# KITTTITAS COUNTY COMMUNITY DEVELOPMENT SERVICES

August 10, 2020

**Subject: Palomino Division 3 (LPF-20-00002) Final Long Plat – Staff Review, Request for Additional Information, Return of Application.**

Surveyed by LMH Scale 1" = 100'
 Drawn by Tml/FCS Sheet 3 of 5
 Checked by FCS Project No. 18146

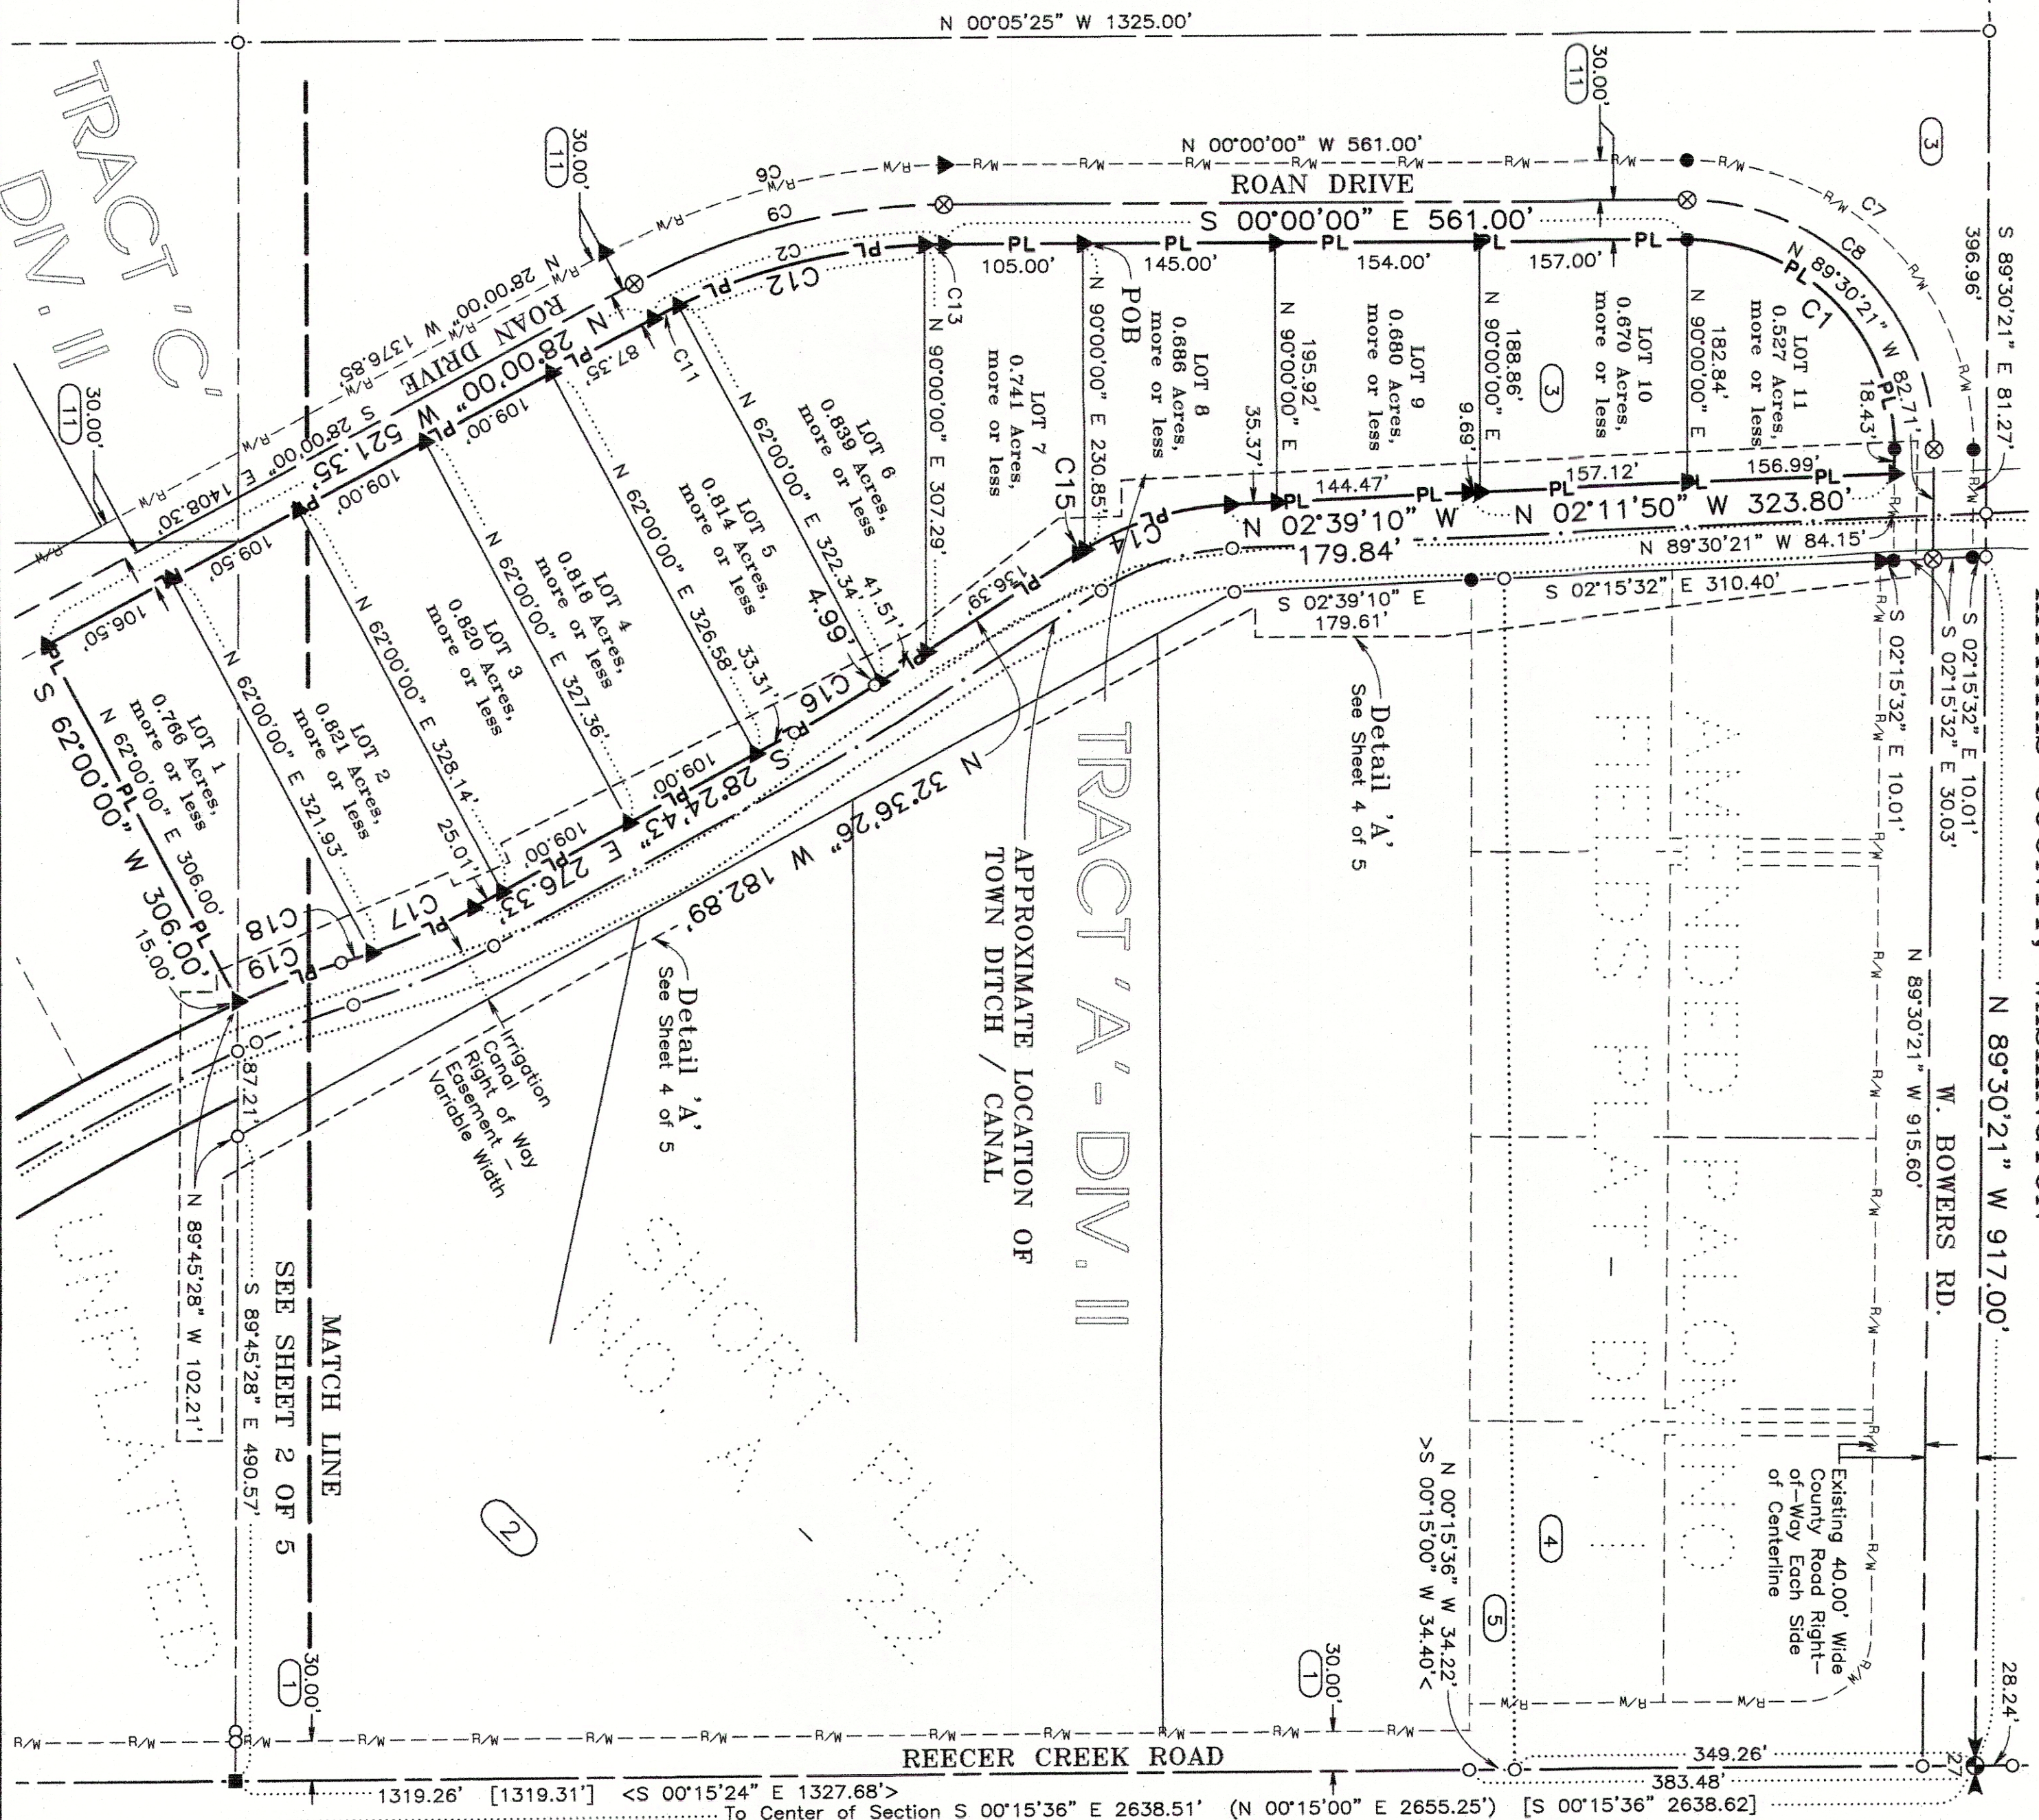
- The final mylars shall express a 100-foot buffer along Currier Creek pursuant to condition VII(B) of Resolution 2008-160.
- LP-07-00031 and LPF-20-00002 shall be included on the face of the final mylars.
- The dedication note outlined in Condition 16 of the preliminary approval resolution 2008-160 shall be added to the final mylars.
- All required plat notes outlined in the preliminary approval resolution 2008-160 shall be present on the final mylars.
